From: [Harmon Rita T.](#)
To: [Fred c. Arfman \(freda@iacivil.com\)](#); "[Genny Donart](#)"; [Bryan Bobrick](#)
Cc: [Olson, Paul L.](#)
Subject: B18D001C - Northpoint Townhomes
Date: Friday, July 08, 2016 8:37:02 AM

Based upon the information provided in your submittal received 6-10-2016, the above referenced plan cannot be approved for Building Permit until the following comments are addressed:

CG1.1

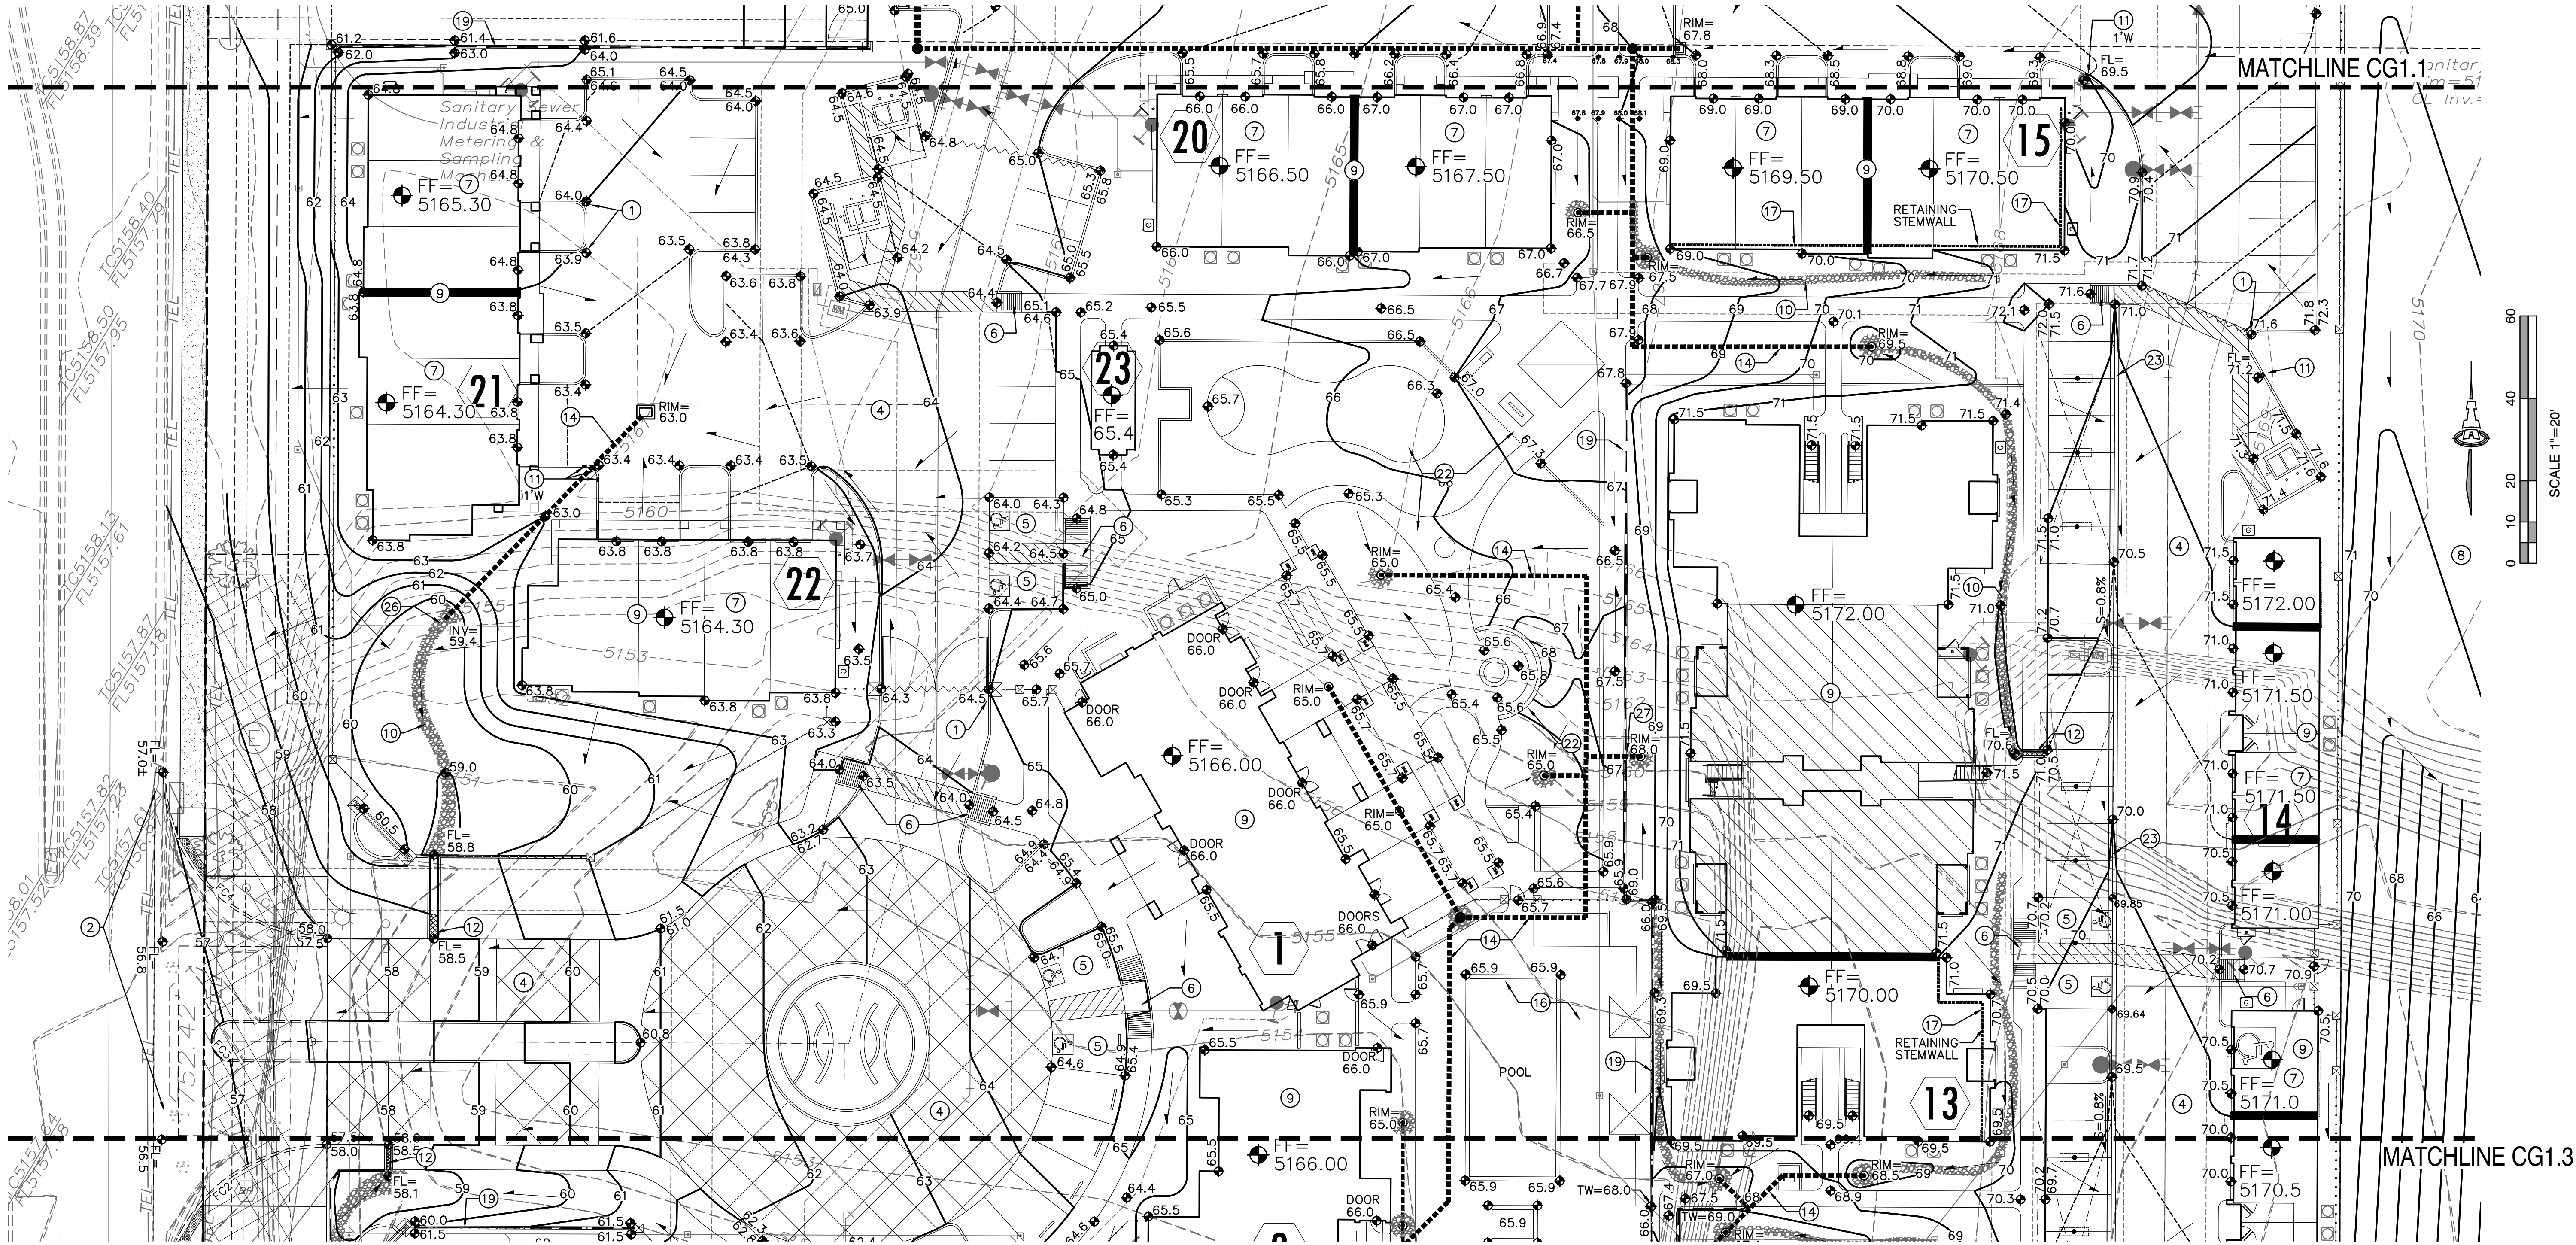
- On Sheet CG1.1, a reference is made to enlarged plan on CG-501 rather than CG5.1
- Building and structure perimeters need to be better defined by using a heavier line weight
